M54 to M6 Link Road
TR010054

**8.8LIU(P) Statement of Common
Ground with South Staffordshire Water**

**M54 to M6 Link Road
Development Consent Order 202[]**

DESIGN SPEED 60kph  
(WORK No. 27)  
HILTON LANE  
LONGITUDINAL SECTION CH. 1000m - CH. 1305m  
SCALE @ A1 - HORIZ 1:1250 VERT 1:250

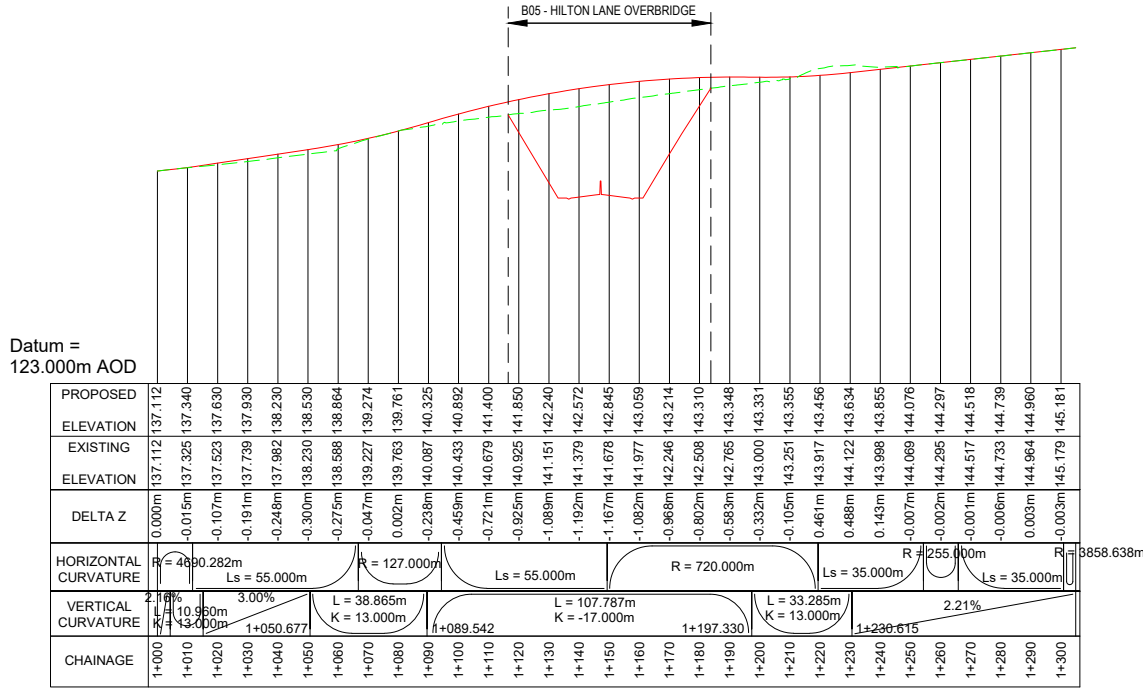
Issue	Comment	Highways England Response	Status	Agreement likely? ¹
South Staffordshire Potable Water Diversion near Hilton Lane	SSW need to ensure that the proposed diversion of the existing 24-inch potable water main is confirmed	Highways England will work collaboratively with SSW to ensure that the diversion proposal meets their requirements.	Under discussion	High
South Staffordshire Potable Water Diversion connection	The proposed connection point for the diversion needs to be confirmed by on site surveys.	Highways England will complete the necessary survey work and will liaise with SSW to ensure that the survey scope captures their requirements.	Under discussion	High

Issue	Comment	Highways England Response	Status	Agreement likely? ¹
Change 5	The change to the scheme here will affect our current proposals as it relates to the alignment of Hilton Lane. Our existing main is located within this section and there are some proposed diversionary works also within this section. Our works will have to be undertaken prior to any of the construction activities at this location so is dependent upon programme alignment to avoid any clashes or delays. Historical option of a diversion route via Hilton Lane overbridge has not been taken forward, as agreed by both HE & SSW, so have been not judged for impact in regard to this change.	Noted. The historic option to divert the asset via the Hilton Lane overbridge was discounted due to the size of the main being unable to locate this within the bridge deck structure. We will continue to work alongside SSW to develop the programme for the detailed estimate for the scheme.	Under discussion	High
